Our Ref: **M/44/12/**
Your Ref:

Town & Country Planning Act 1990 (as amended)
Town and Country Planning (Development Management Procedure) (England) Order 2010 (as amended)
Application for Planning Permission

Development Change of use from storage for D2 use to a holiday let (C1)
Location Middleton Sports Club 3 Sea Lane Middleton-on-Sea

**LOCATION PLAN
SITE PLAN**

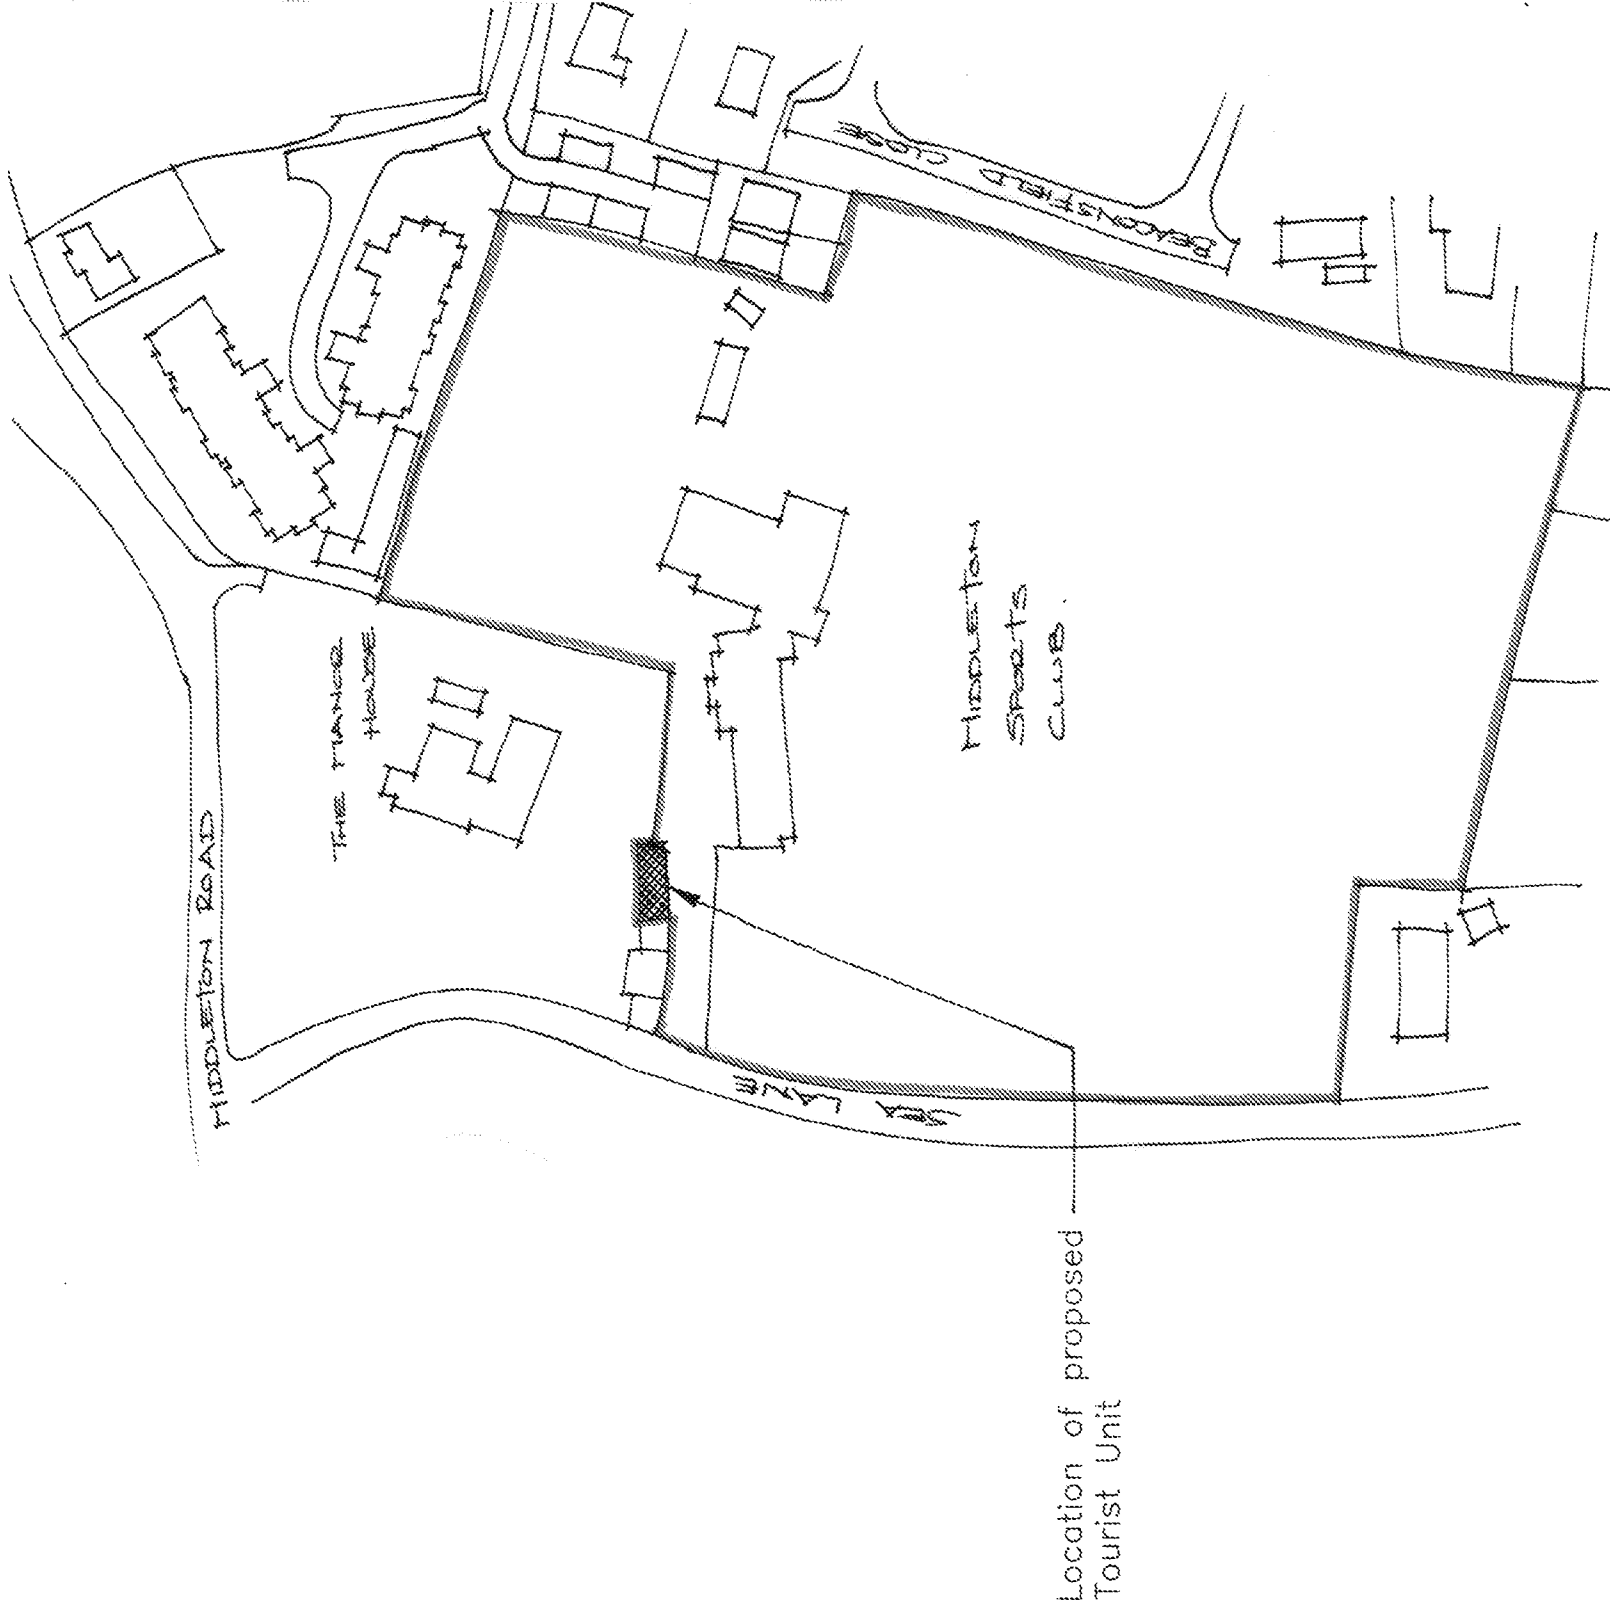
I require 1 electronic or 3 paper copies of a block/site plan in accordance with the guidance notes available on our website detailed below (click on National List). Also, please show where the rubbish bins/recycling bins will be located. *- Not shown on amended plan.* ~~x~~
